**RE: 2205-178-SUB1-PLANS, 6454 East Mercer Way
Civil Plan Revisions per City Comments**

This letter accompanies revised civil plans in response to City comments of November 16, 2022. Each correction item is discussed below.

A1.1

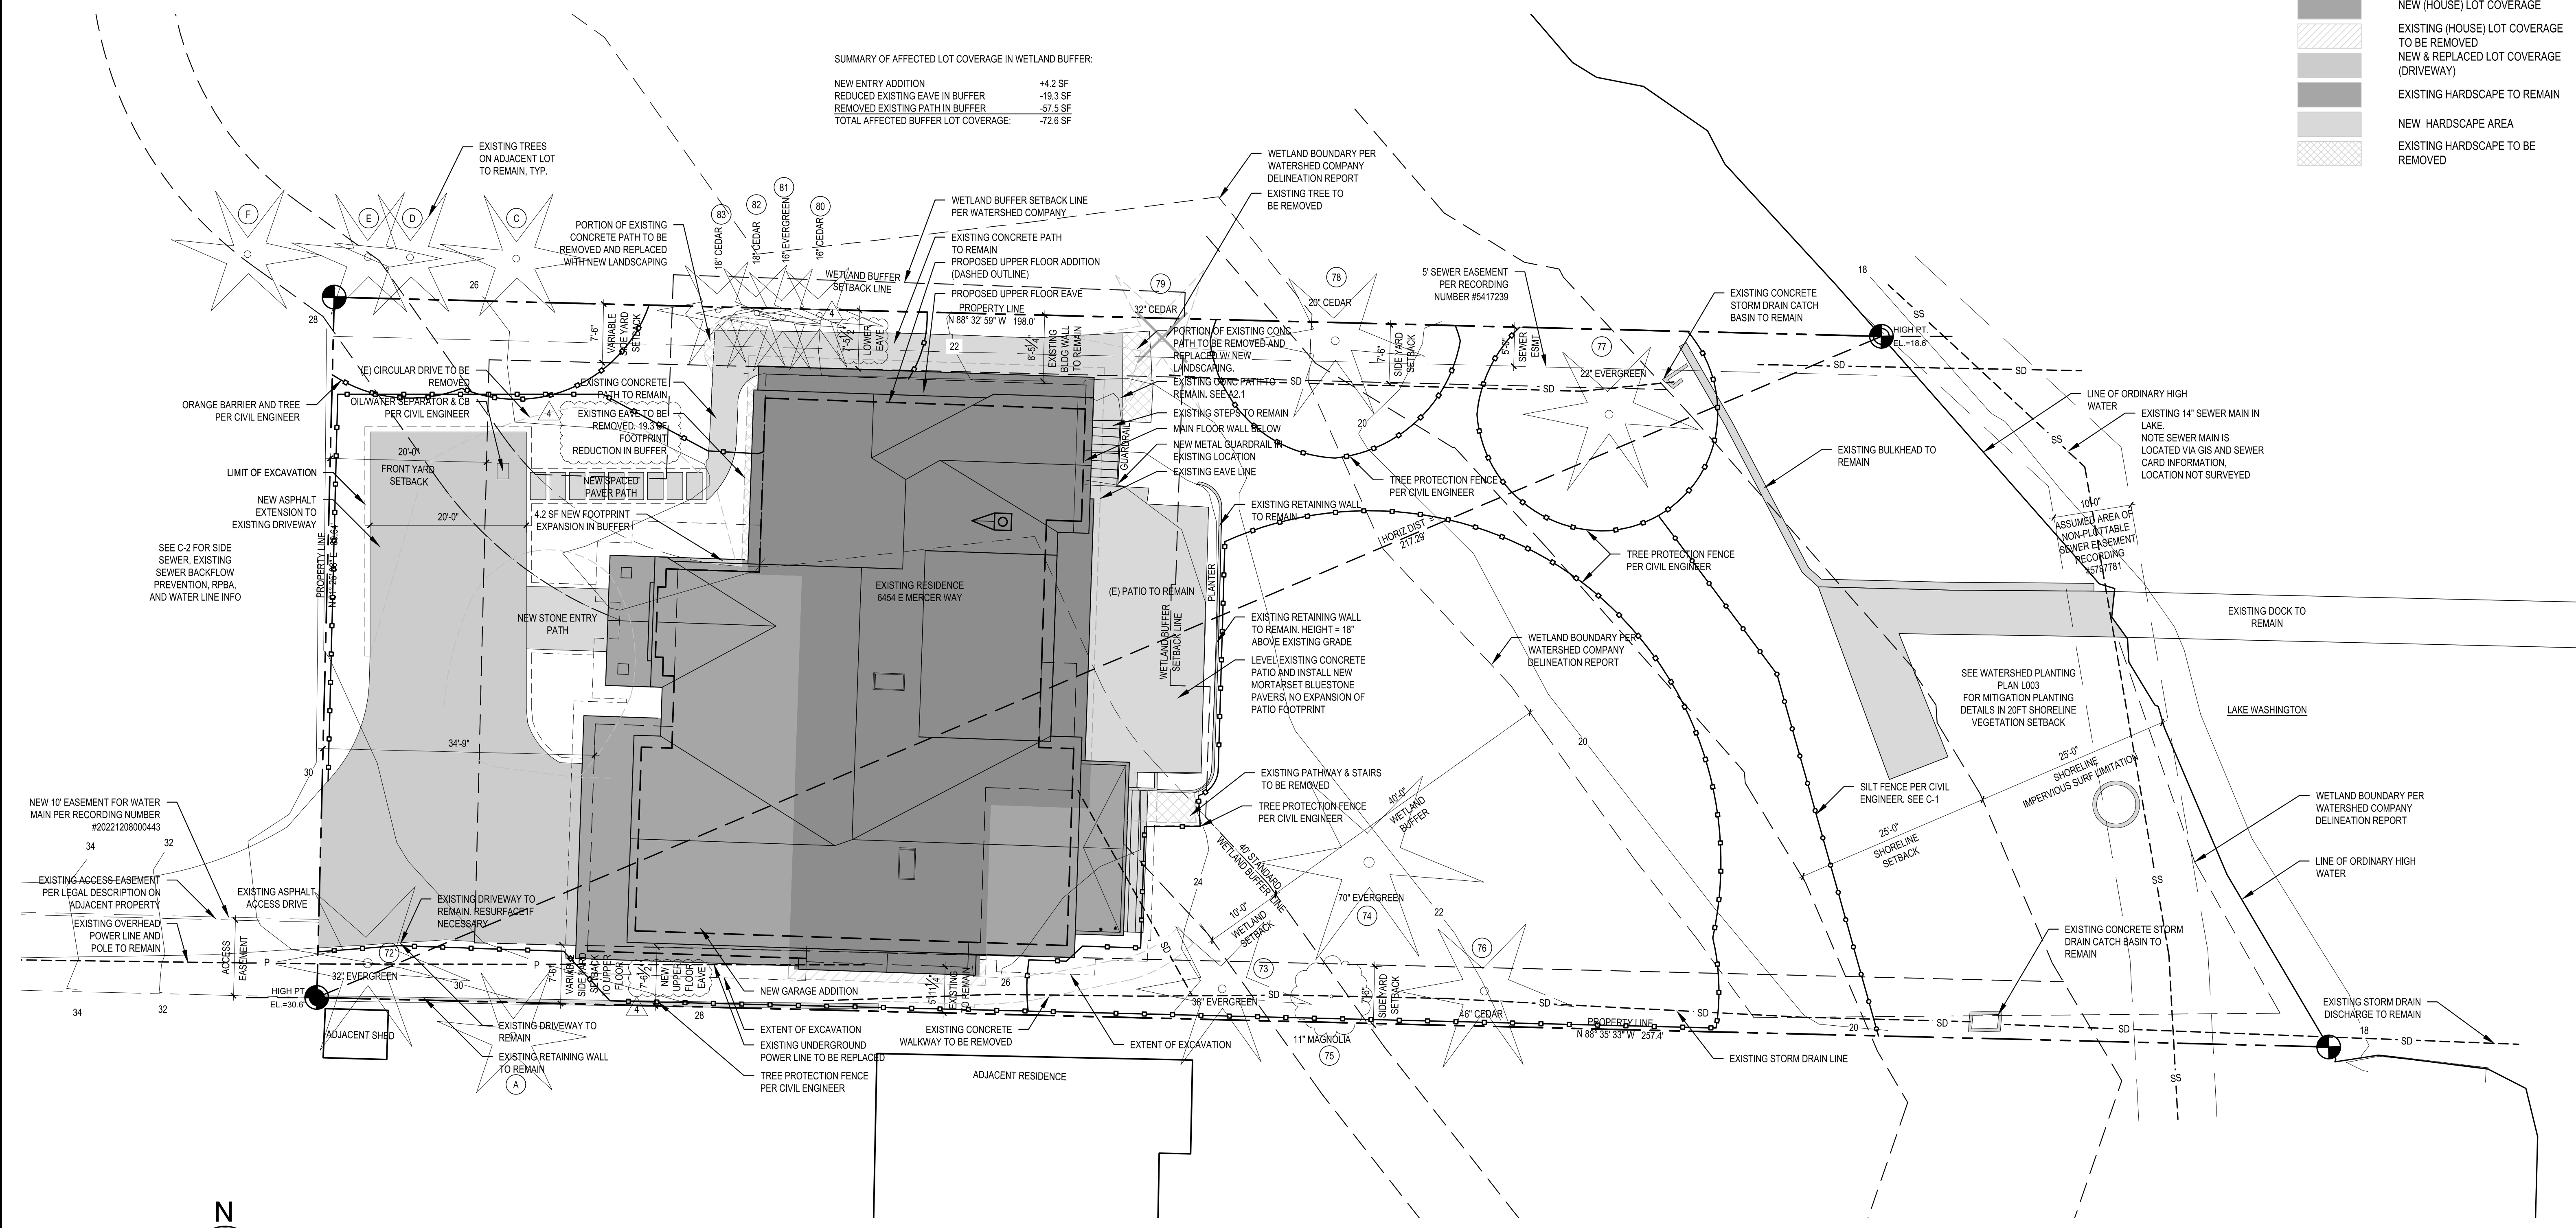
1. Arch. plan proposes a sewer backflow while civil plan calls out an existing one - which is it? Arch. site plan to remove side sewer info. A sewer backflow prevention valve is required if one does not exist.

6. RPBA locations between arch. and civil do not match - arch. site plan to remove this info. The RPBA must be located on the 6454 E Mercer Way lot and within 50' of the western property line.

According to the City sewer card (attached) there is an existing backflow preventer at the location shown on the plan. A note has been added to replace the preventer if directed by the City inspector. The preventer has been removed from the architectural plan.

The RPBA has been removed from the architectural plan. The RPBA has been relocated to onsite within 50 feet of the west property line.

SHEET: C-1

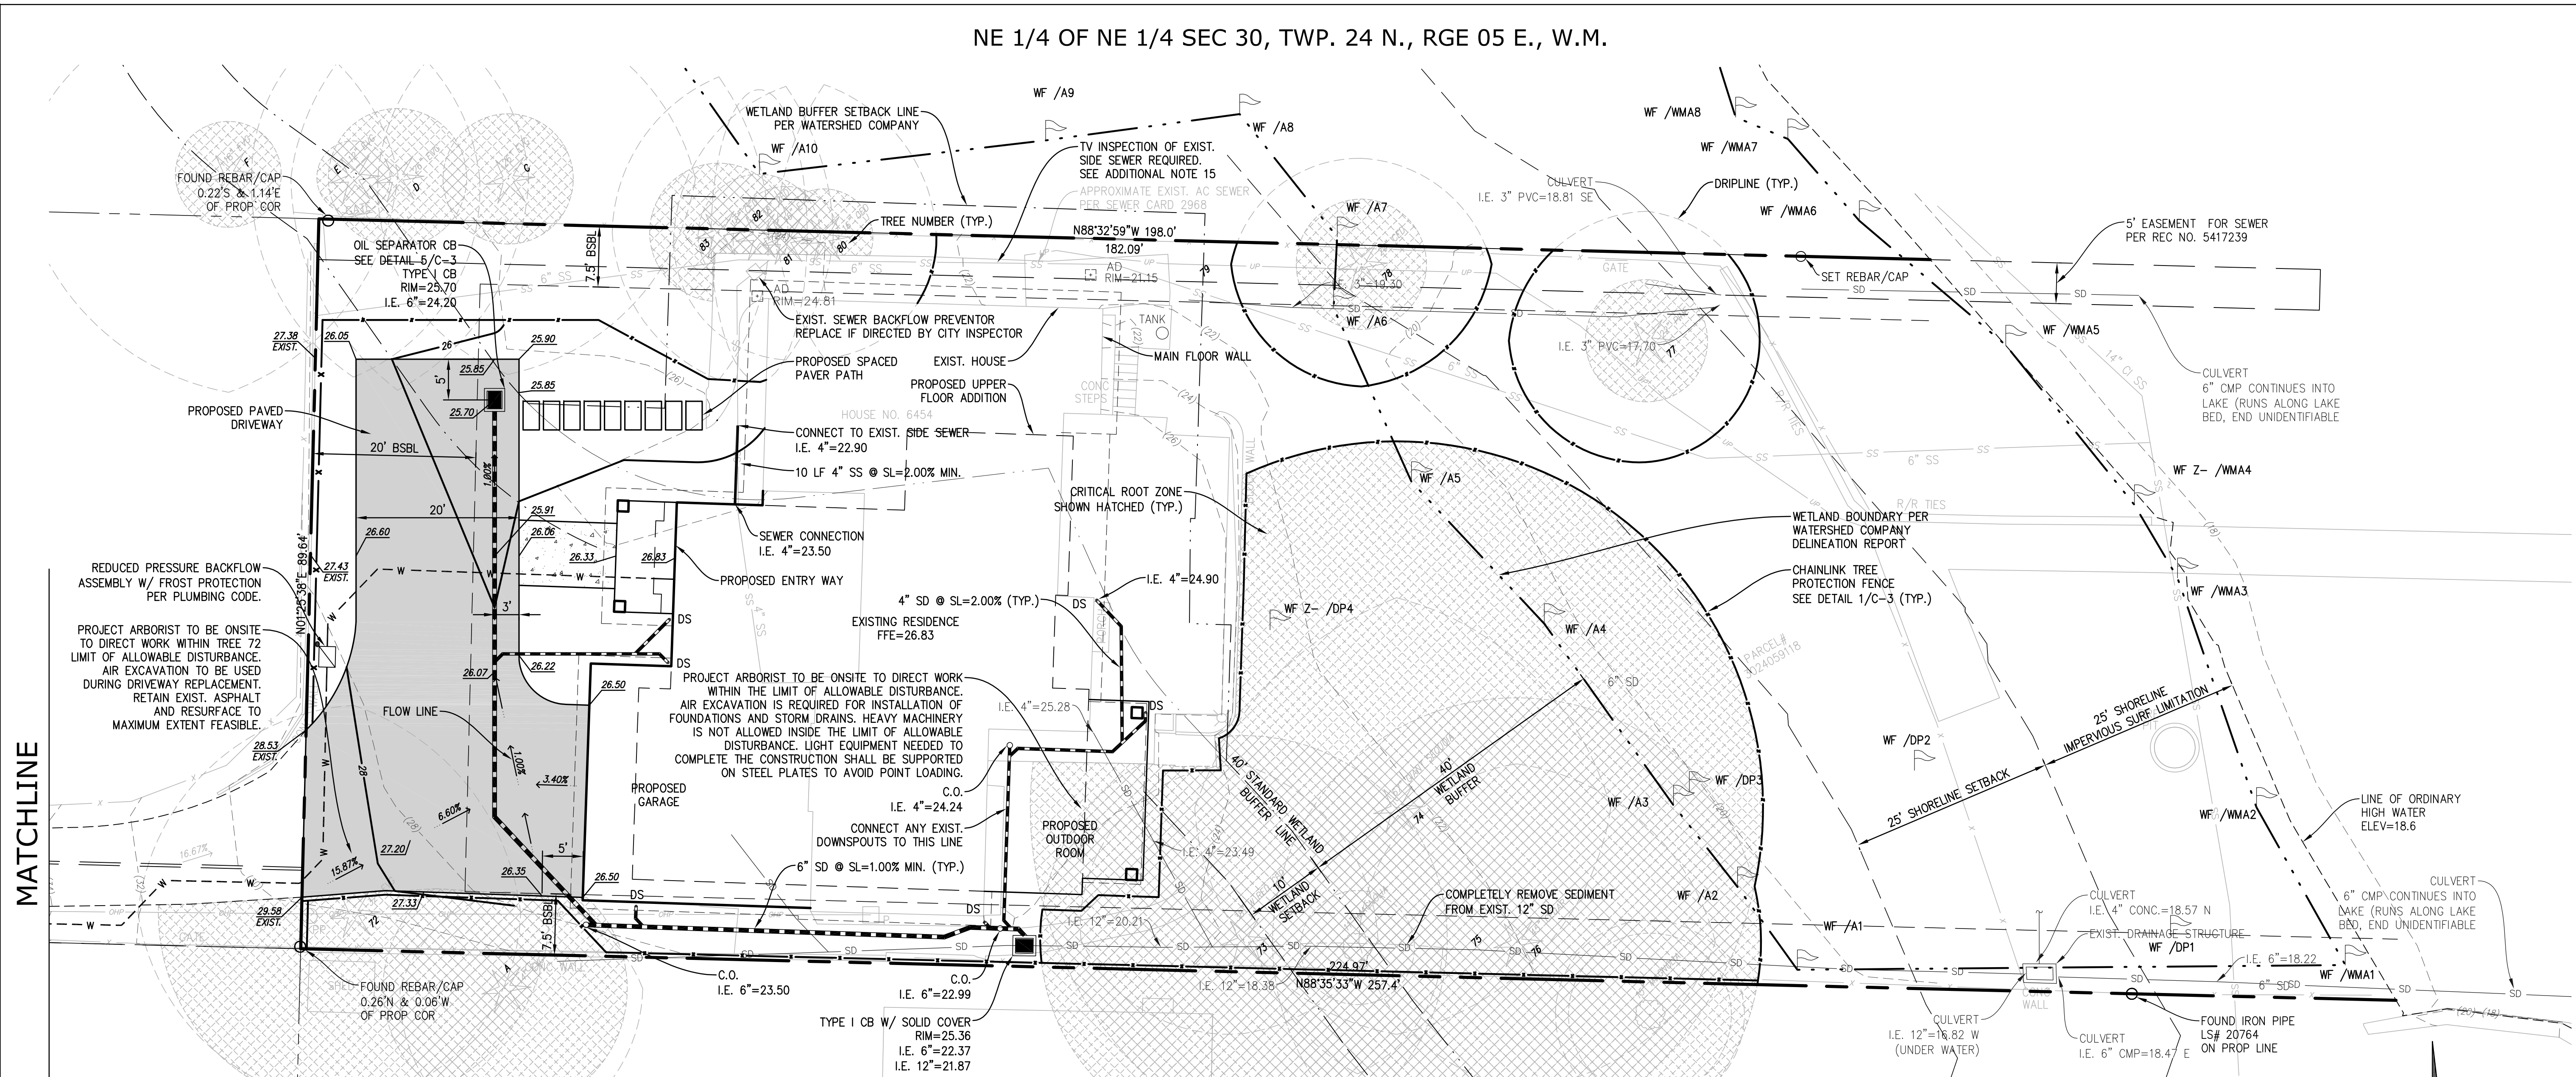
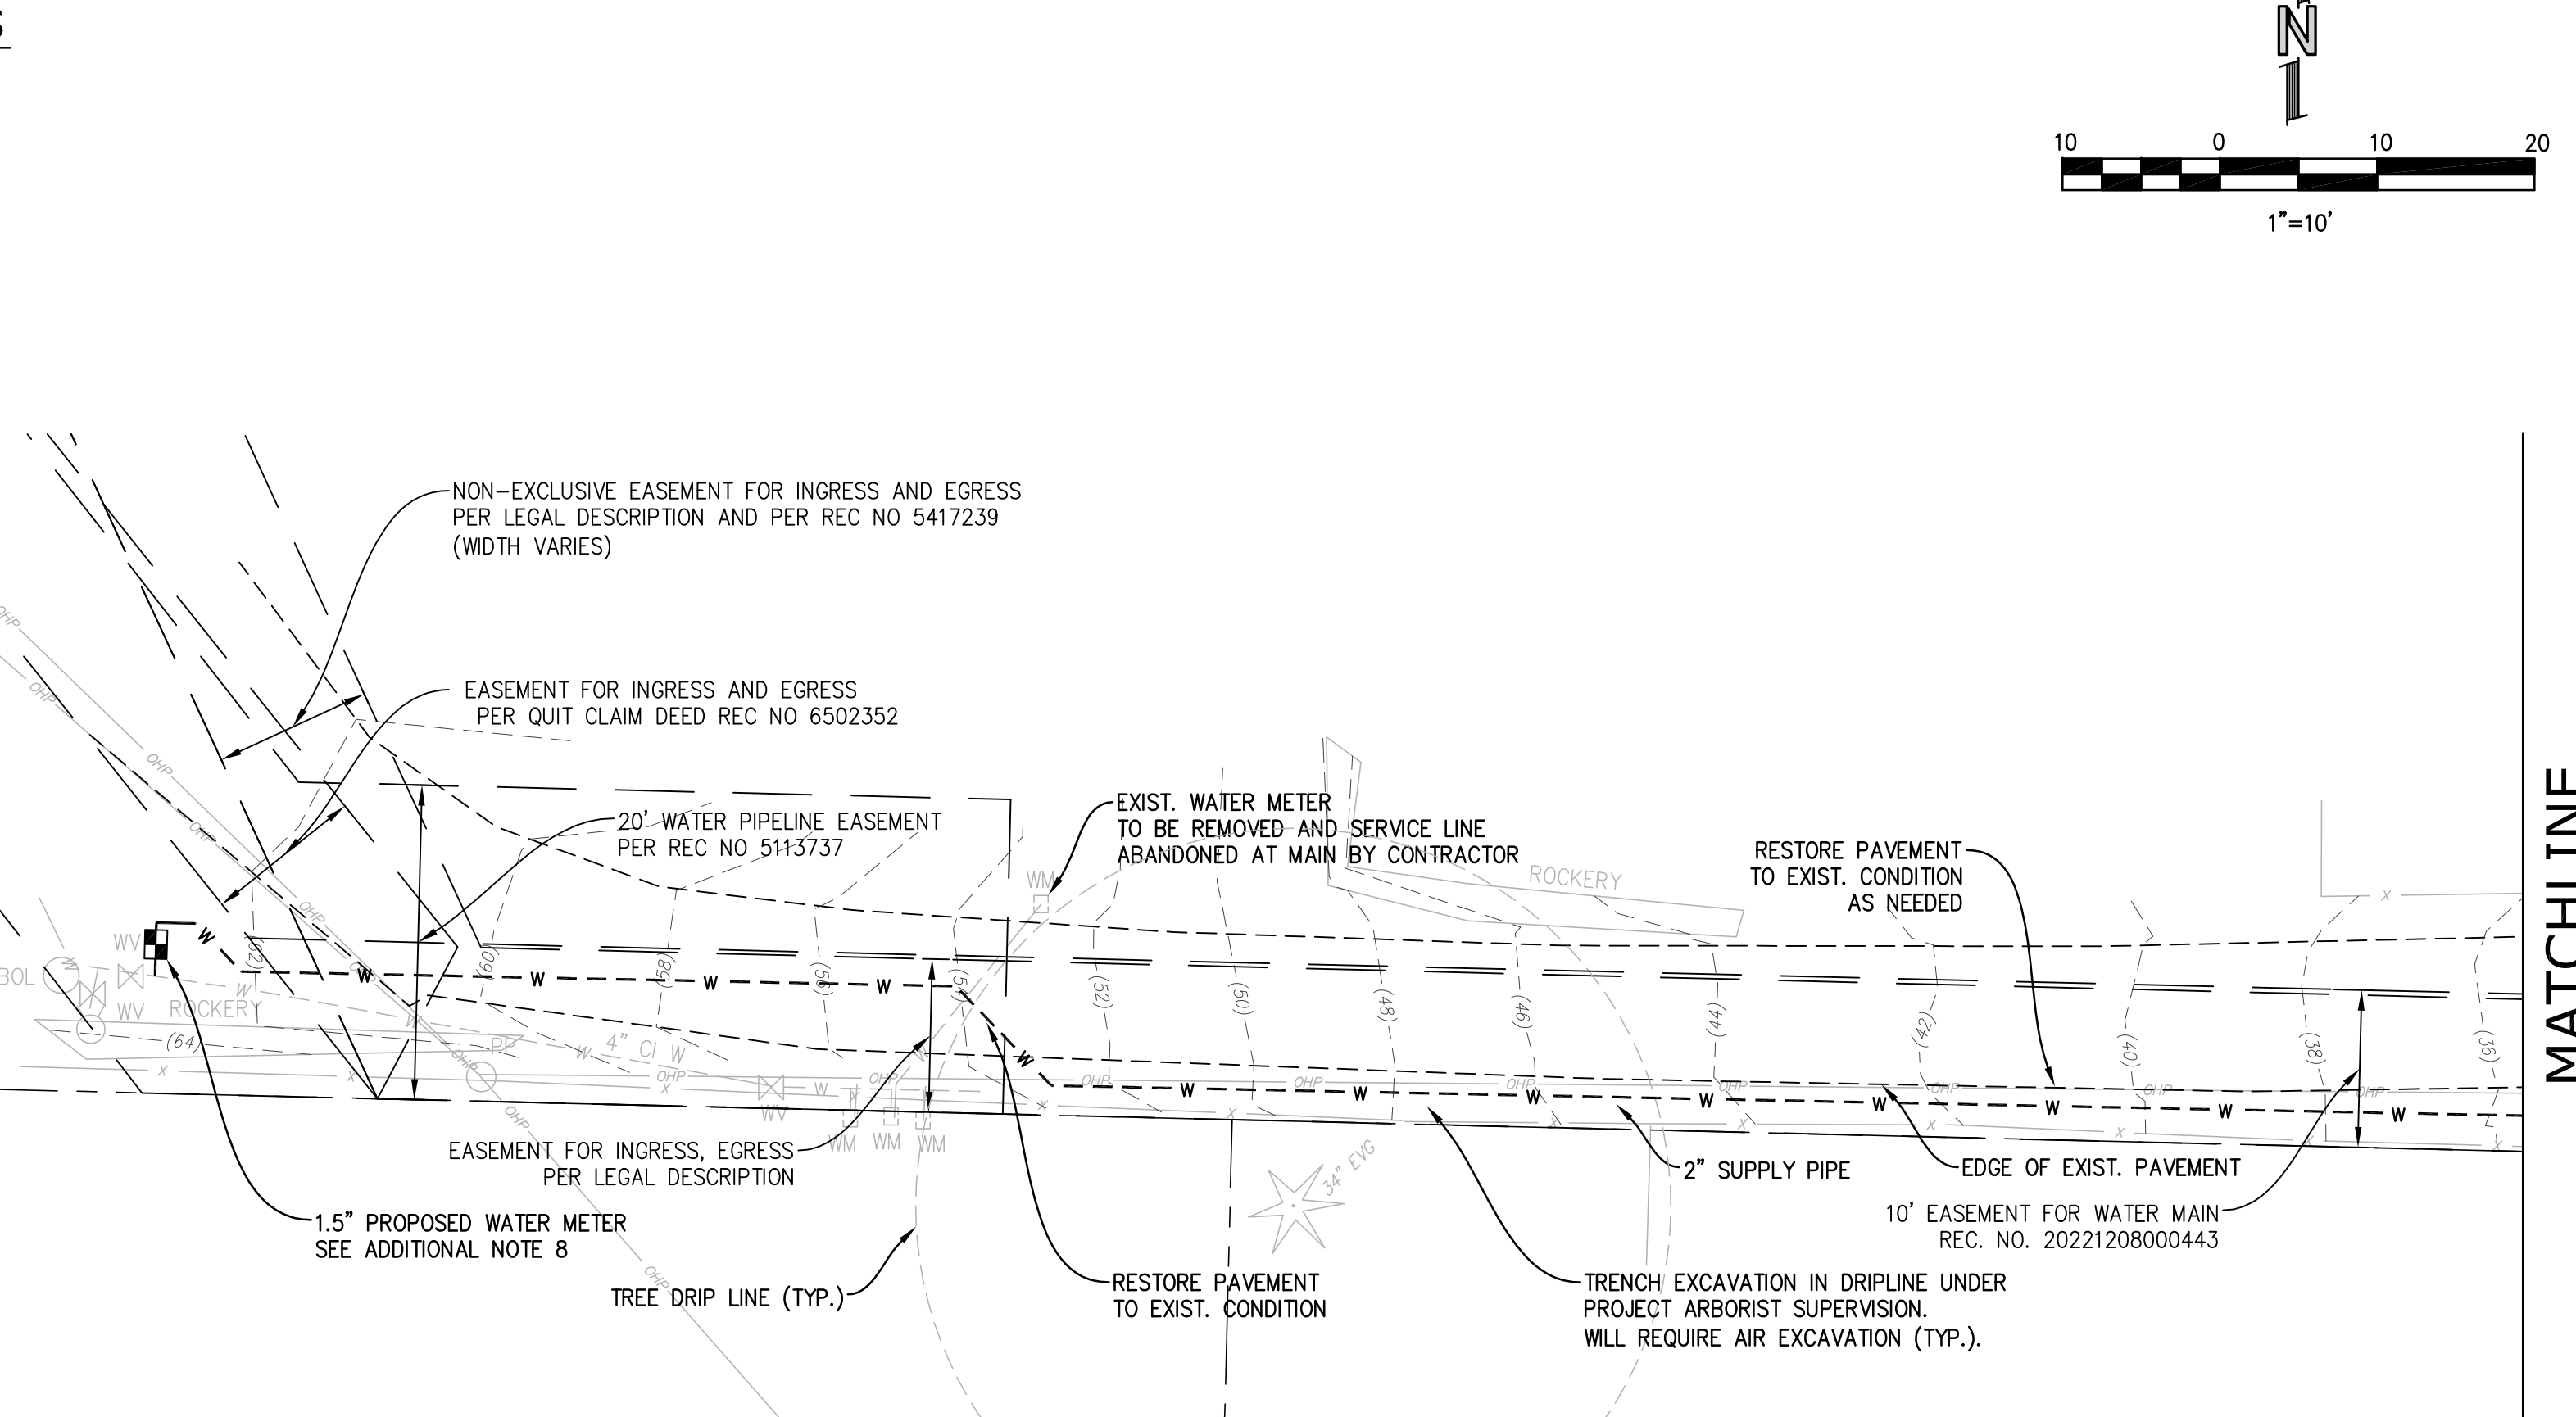
2. This needs to be connected with a CB and located outside the tree drip line.

3. Storm video and aerial photo markup that was provided with storm videos indicates (2) roof drains in this area daylighting in the garden. Tightline these drains to the conveyance system.

4. Storm video ends approximately in this area - engineer must verify that the existing condition of the pipe from the point of connection to the drainage structure is feasible.

5. Aerial photo markup that was provided with storm video indicates that the existing pipe is 60% filled with sediment. Engineer to evaluate if mitigation is required and show on plan.

7. Please show easement recording number, pavement edge, and tree drip lines. Pavement edge and easement line types are currently the same, please differentiate. Does this ingress and egress easement allow utilities? Legal description on survey drawing only mentions ingress and egress. Provide the recorded easement documentation with highlighted language indicating rights to install utilities. The City will determine the new meter location once the above information is shown on the civil plans.

A CB has been added outside the dripline.

The existing downspouts will become redundant when the existing roof is replaced in this area. However, we have added a call-out to connect any existing downspouts to the new storm drain.

The video upstream of the sediment shows the pipe to be in adequate condition and it is reasonable to assume that it is also in adequate downstream to the drainage structure. To our knowledge the pipe system has been performing with no observed backup or flooding.

A call-out has been added that directs sediment to be removed from the pipe.

The surveyor has been unable to locate the recording number of the ingress/egress easement or a document for the utility easement. Pavement edge and tree driplines are shown on the plan and called out. Line types have been revised.
